Re: ABP-TA 06F.313361

We, Doyle Kent Ltd. of 71 Carysfort Avenue, Blackrock, Co. Dublin, wish to submit an observation in relation to the SHD application TA 06F.313361 - lands at Back Road / Kinsealy Lane, Broomfield, Malahide, Co. Dublin. The observation is on behalf of two families with residential property adjoining the SHD site – Ken and Carol McAllister of *Lermoos*, Back Road, Malahide, Co. Dublin K36 WK46 and David Linehan and Aimee McAllister-Linehan of Back Road, Malahide, Co. Dublin. The McAllisters have lived at this location since the 1970s. Recently, their daughter, Aimee, and son in law (David) have built a new dwelling on part of the family property per Plan Ref. F20A/0507.

Boundary Treatment | Northern Section | 1:1000

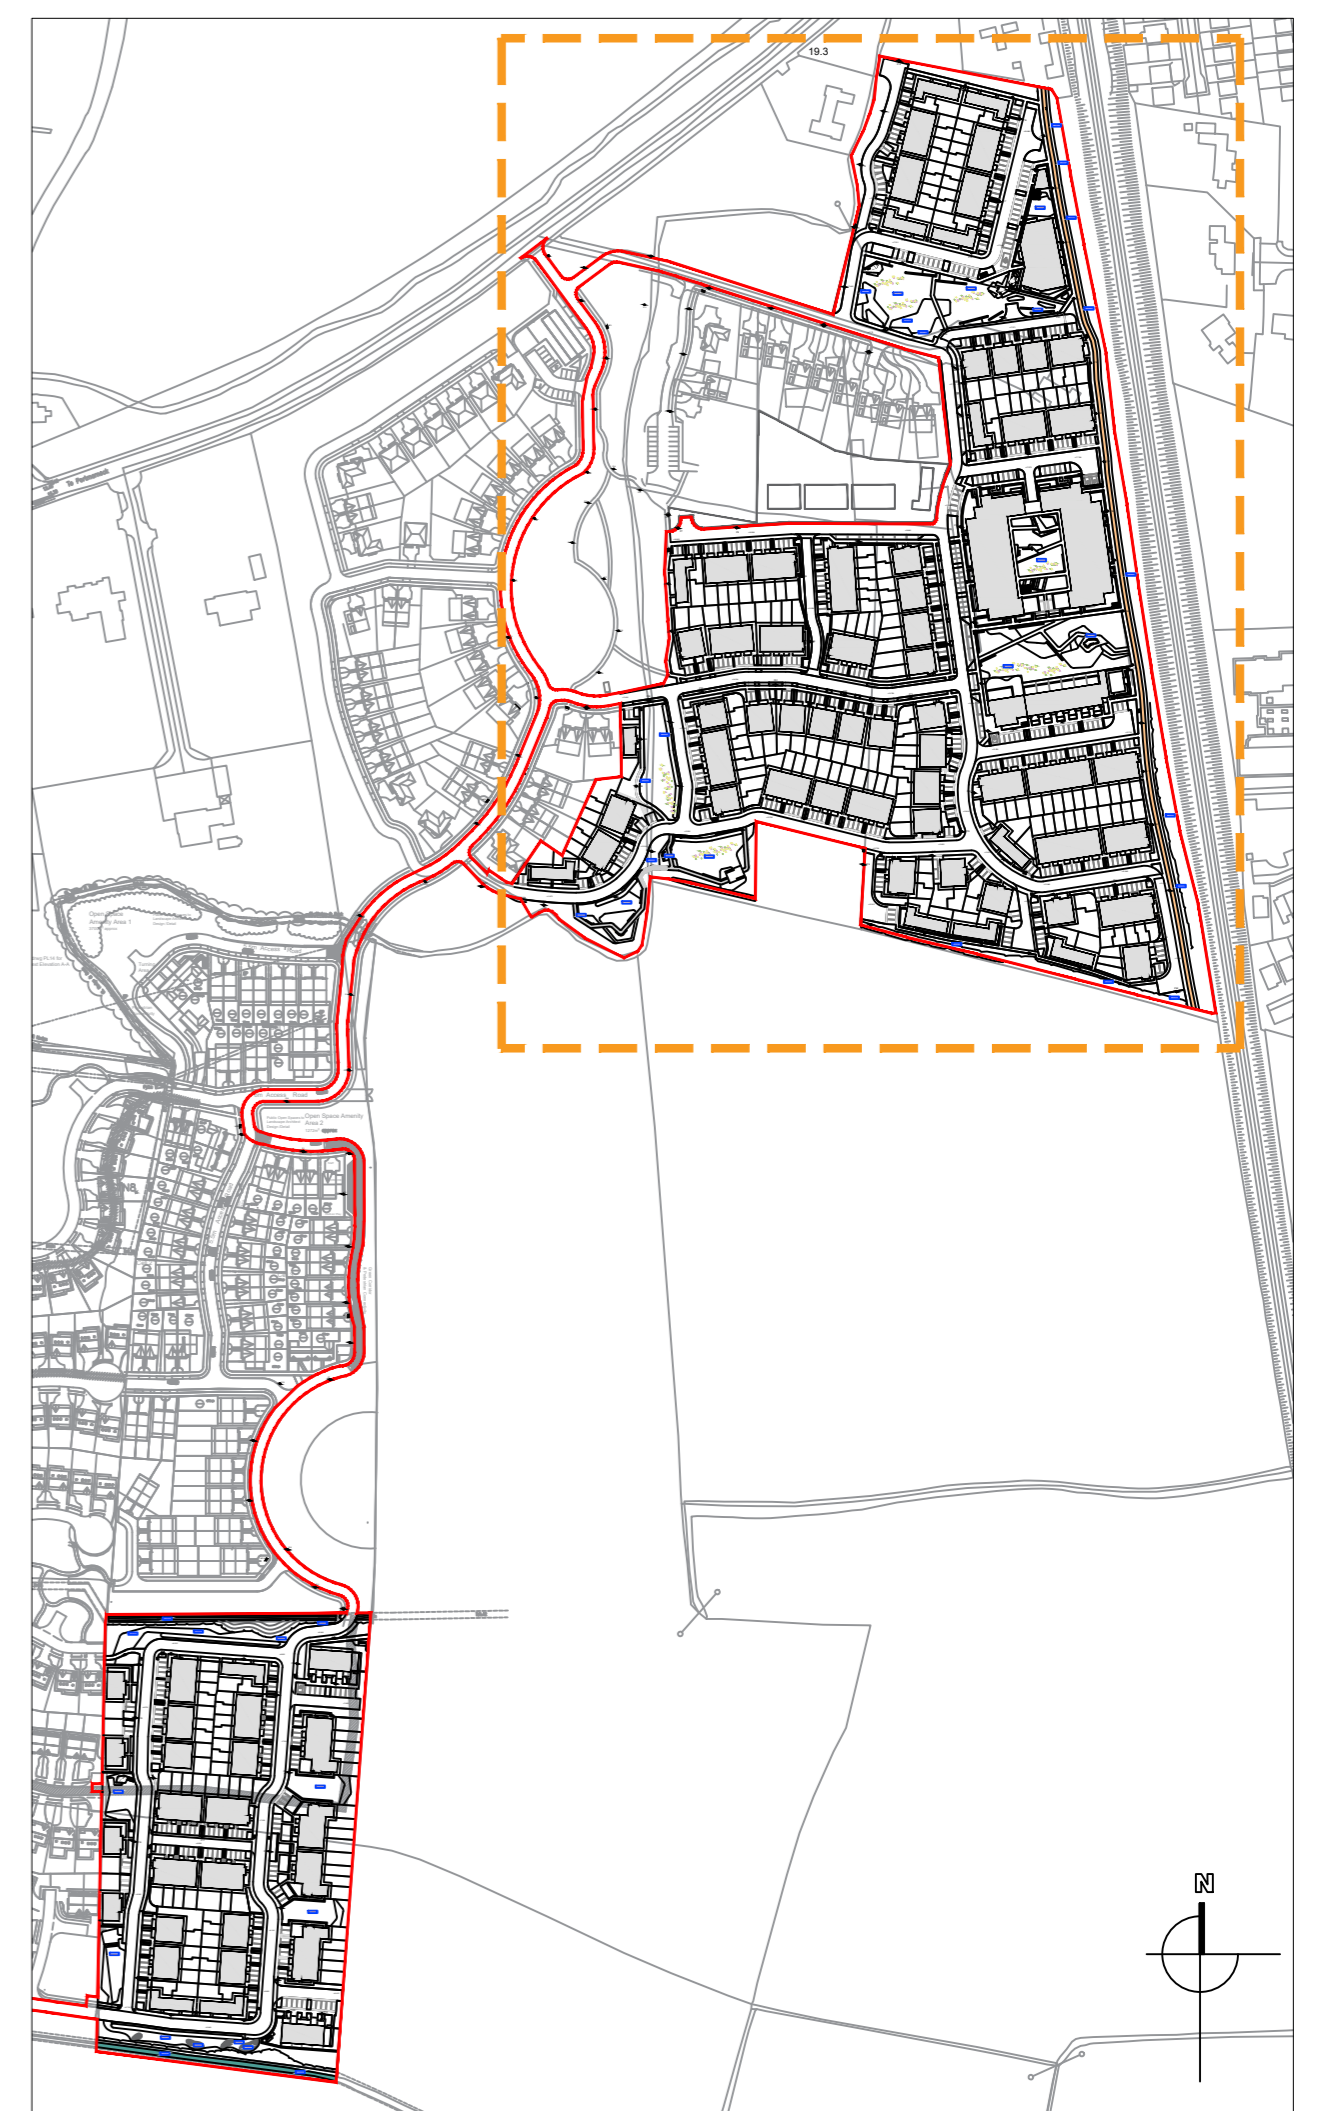
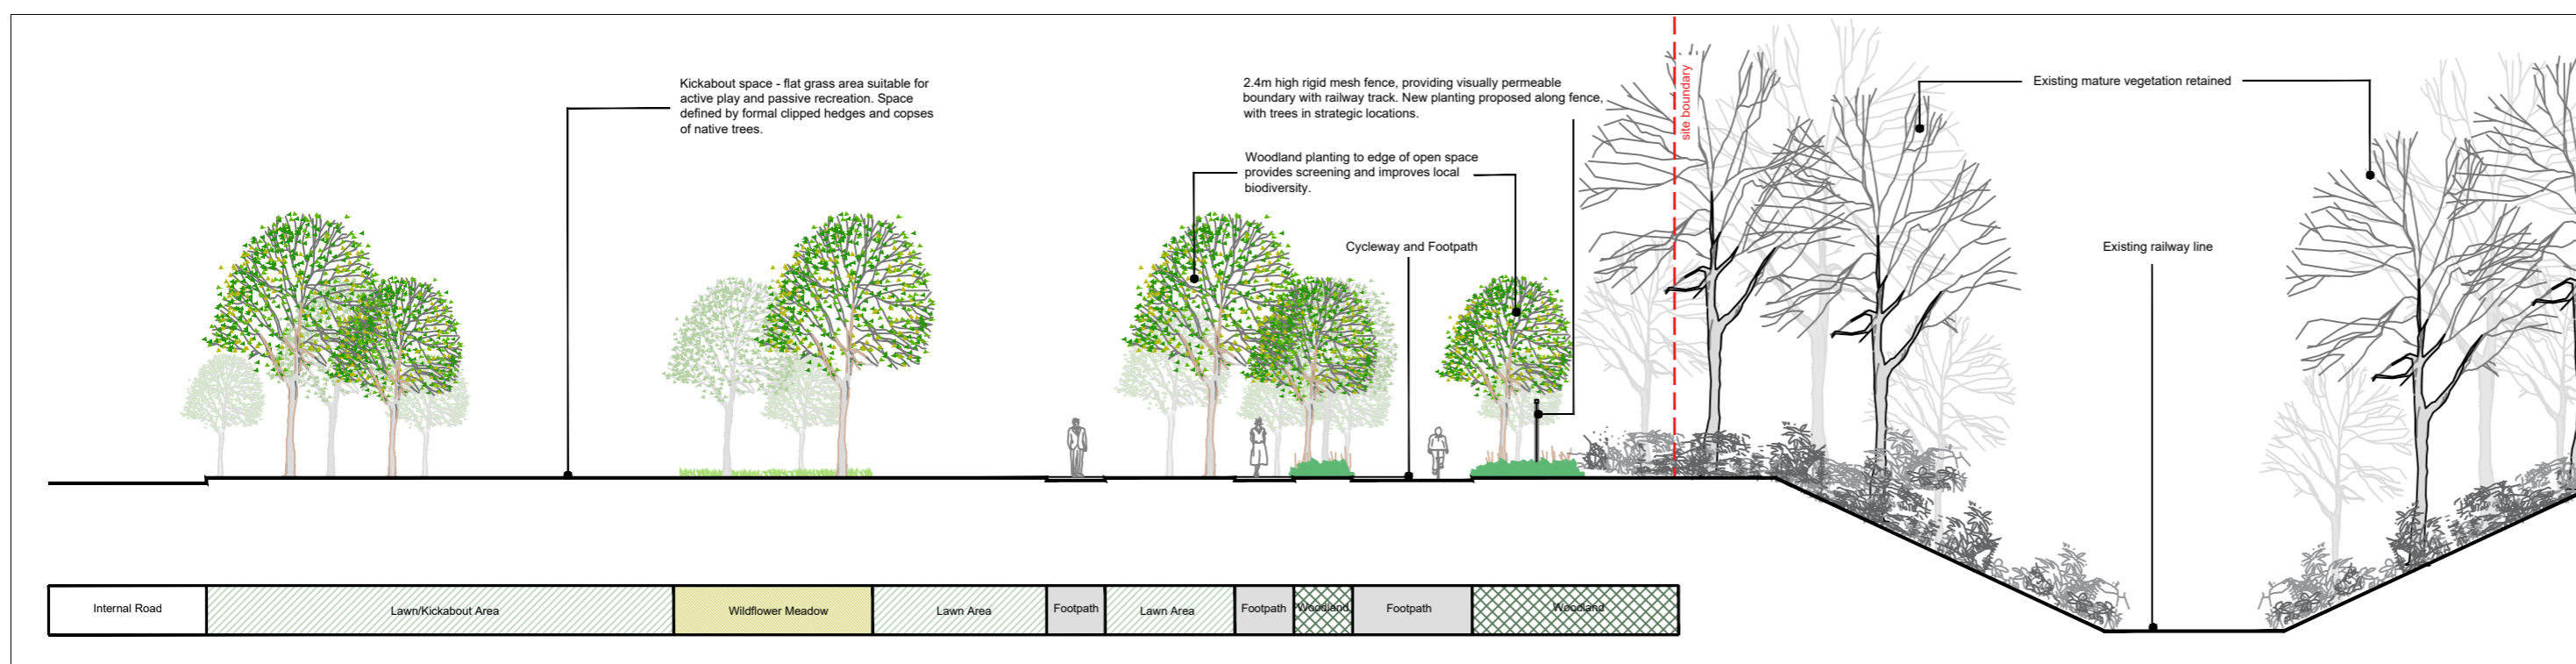
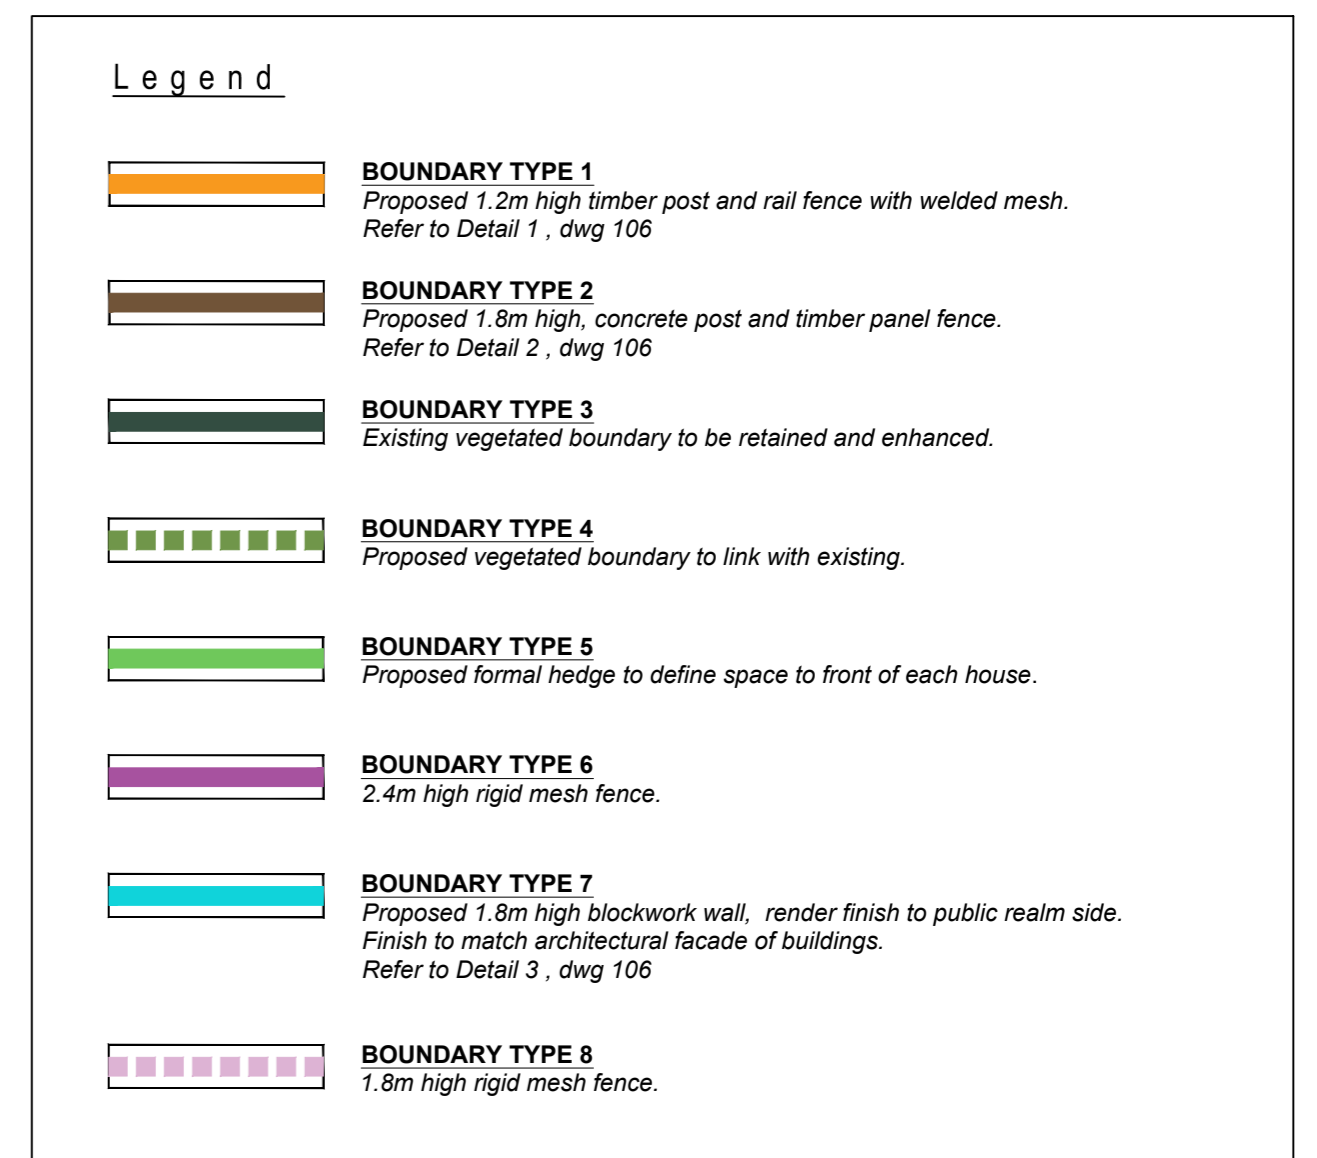
The proposed layout entails construction of a new cul-de-sac road immediately to the rear of our clients' dwellings. The Board might please note that anti-social behaviour has become a problem in this area. A matter of considerable concern is the relatively open nature of the existing boundary between our clients' properties and the proposed cul-de-sac. Only minimal intervention is proposed in the SHD to the boundary to form a new fence of 1.2m height. This is entirely inadequate in terms of security and will leave our clients' properties quite open and insecure. We request the Board to attach a condition requiring a 2.4m high wall, suitably rendered and capped, along this boundary with the future public realm. In the alternative, there should be a very robust fence of palisade type of similar height. It is not reasonable to leave a boundary to the (future) public realm so exposed, notwithstanding the existence of some poor quality trees (predominantly sycamore) in this location.

Notwithstanding the provision of a landscaped strip between the SHD road and our clients' properties, the location of the new road will give rise to noise impacts and some intrusion from headlights at night time. Of particular concern is the location of a turning head immediately to the rear of the Linehans' property, which will cause some significant impact from vehicles turning. Again, we submit the proposed boundary treatment is simply inadequate and should be replaced by a robust wall of 2.4m height.

SITE PLAN

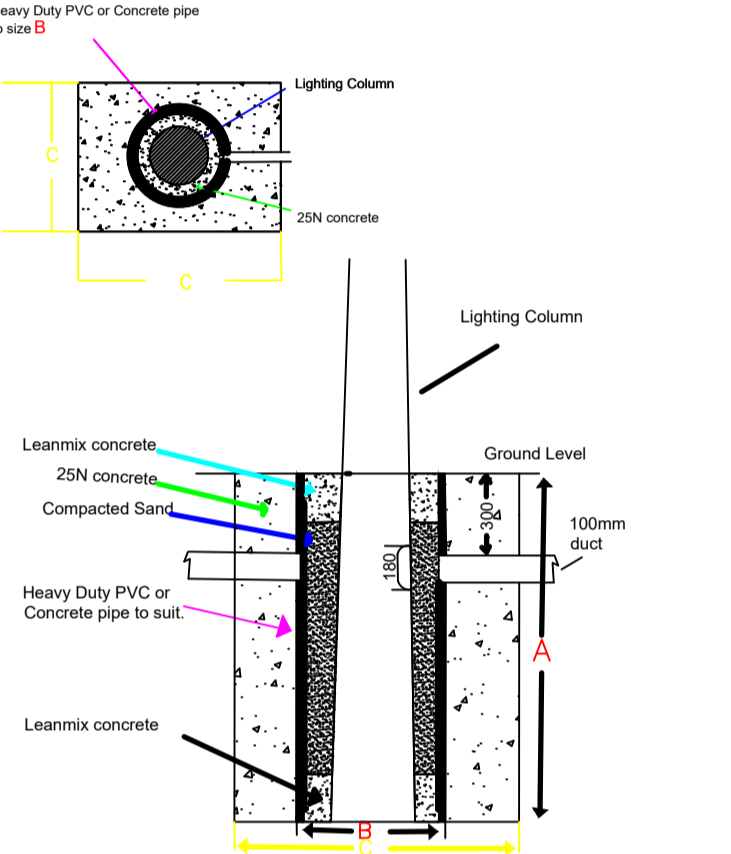
We note the lighting layout (Sabre Dwg No. SES 14620) submitted with the SHD application appears to show some light overspill into the existing residential properties including those of our clients, especially from Light P14 into the garden of the Linehans' new house. We could not see a key to the diagram on the drawing, but would respectfully request the Board to attach a suitable condition to the effect that all public lighting should be directional and meet current anti light pollution measures so as to avoid unnecessary overspill into our clients' properties.
